Department of Primary Industries

**Northern Beaches Hospital Connectivity and Network Enhancements Stage 2
(SSI_6622)
Response to exhibition of Environmental Impact Statement**

Northern Beaches Hospital Connectivity and Network Enhancements Stage 2 (SSI_6622) Response to exhibition of EIS Detailed comments by DPI Water

Surface water quality sampling locations Figure 16-2

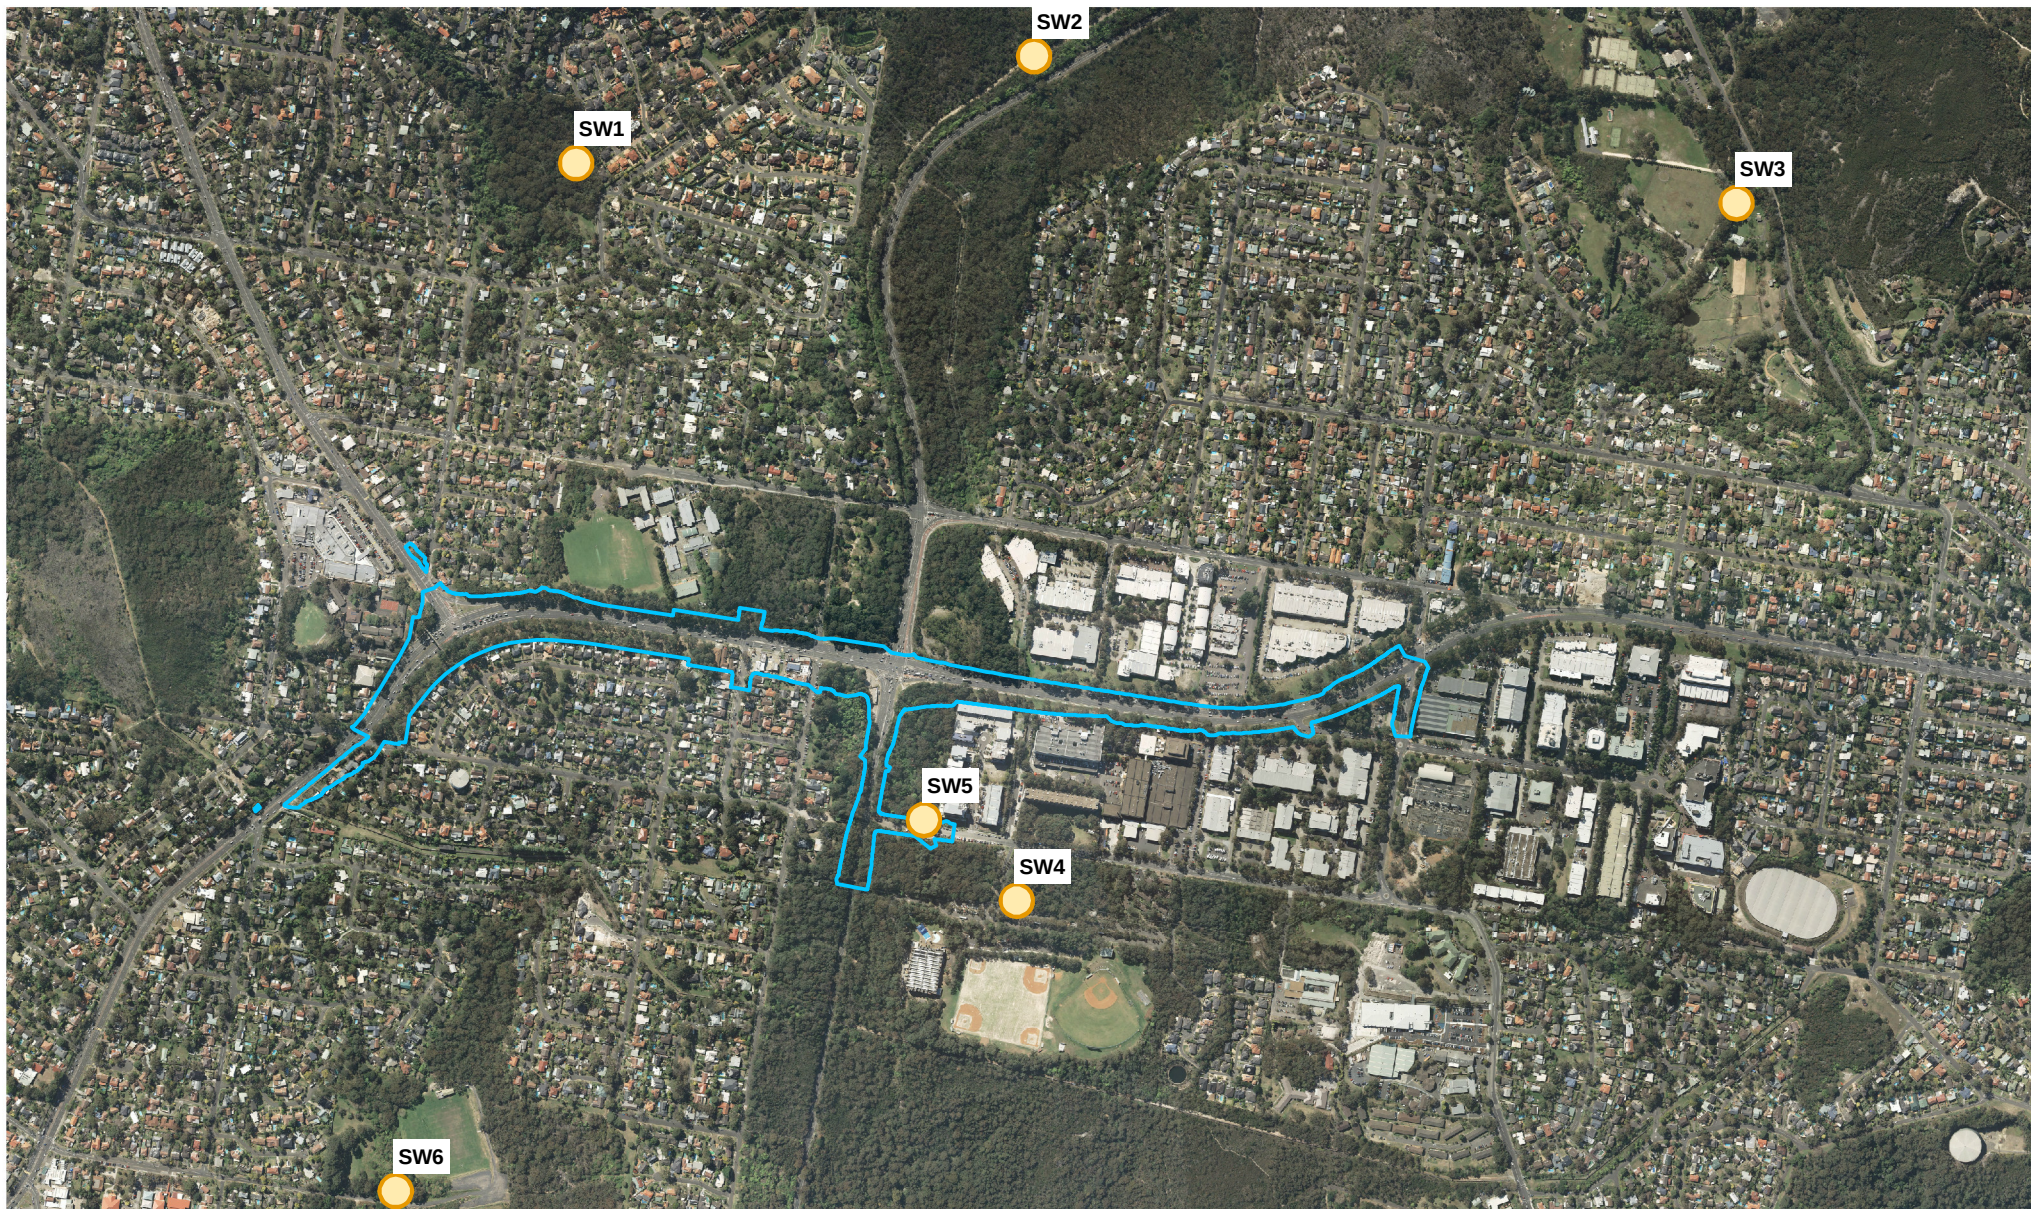
Section 16.2.3 notes surface water sampling was carried out at five locations (SW1 to SW5) as shown on Figure 16-2 and four sample events have been completed (page 339). The surface water sampling is not considered adequate in terms of detecting impacts on the waterways potentially affected by Stage 2. Additional sampling sites need to be added to the monitoring locations, including longitudinal sampling sites along each relevant waterway and control /reference sites so as to interpret data from these sites and determine if an impact has occurred (ie detect any trends downstream) and to determine the recovery potential of the site.

Pre-construction sampling needs to continue as 4 sampling events do not cover a sufficiently long period of time to be representative
